RE: **Lot 15 Block 2 Unit 5 Unser Cliffs SAD 227**
6912 Rimrock NW
Grading and Drainage Plan
Engineers Stamp Date 7/18/17 (D10D009)

Based upon the information provided in your submittal received 7/18/17, this plan is approved for Grading Permit.

ENGINEER'S SEAL	6912 RIM ROCK	DRAWN BY WCWJ
	GRADING AND DRAINAGE PLAN	DATE 7-15-17
		21764-LAYOUT-7-14-17
7/16/17		SHEET #
DAVID SOULE P.E. #14522		JOB # 21764

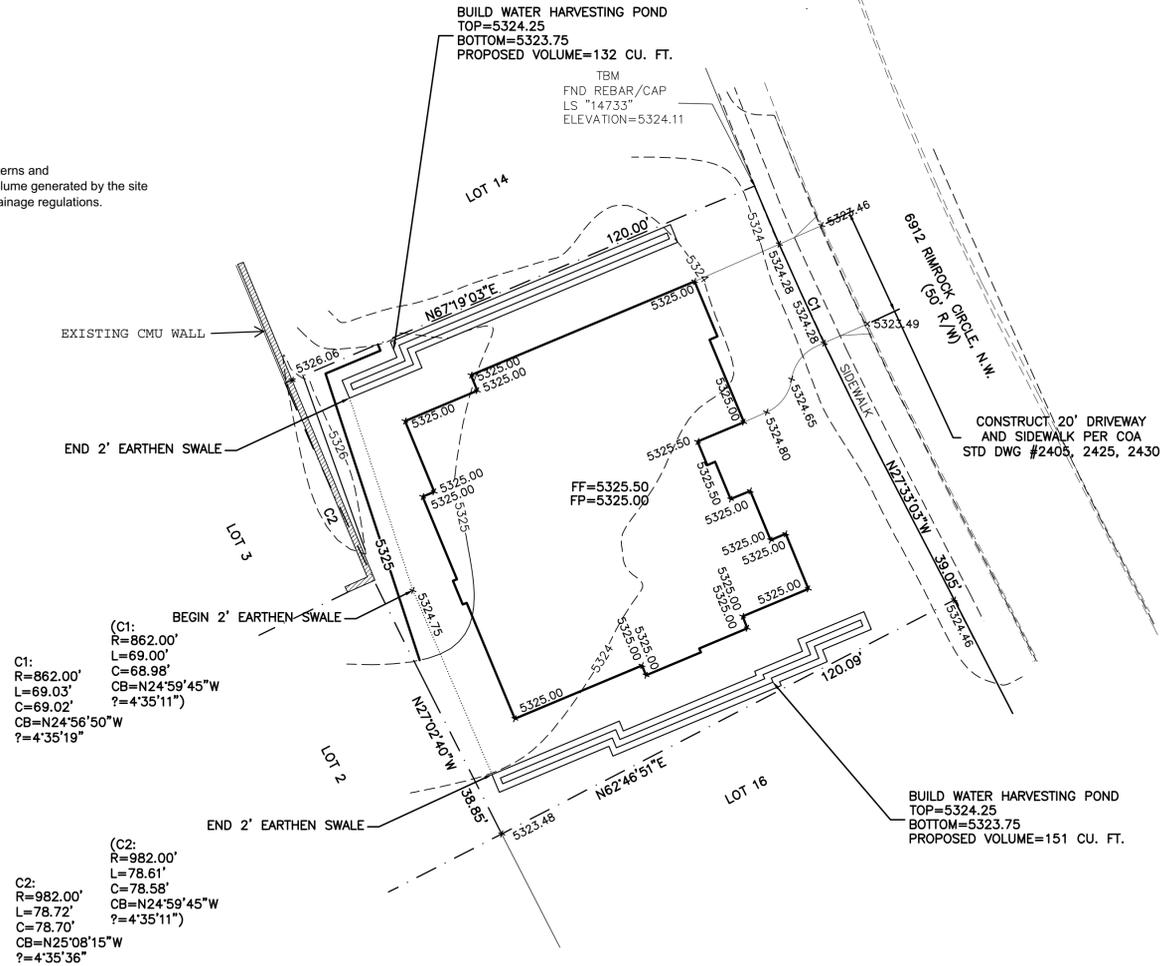
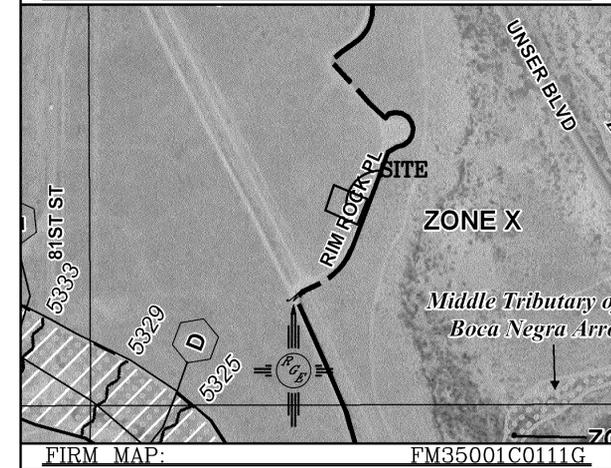
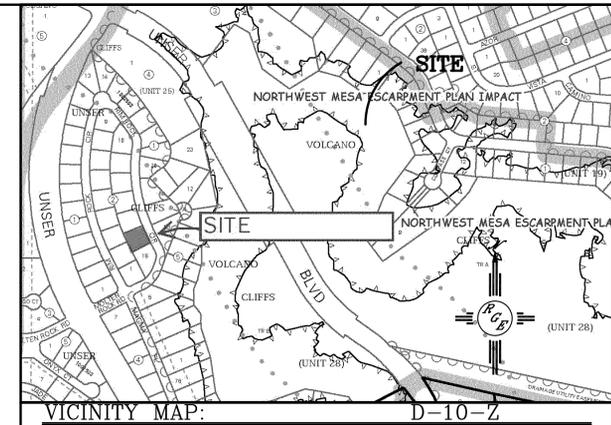
- Provide a statement on the plan stating that this grading plan must be used for the application of any garden/retaining walls. **added language to note #3**
- Provide a statement that a Pad Certification is required before building permit can be approved. **note#4 shows this**
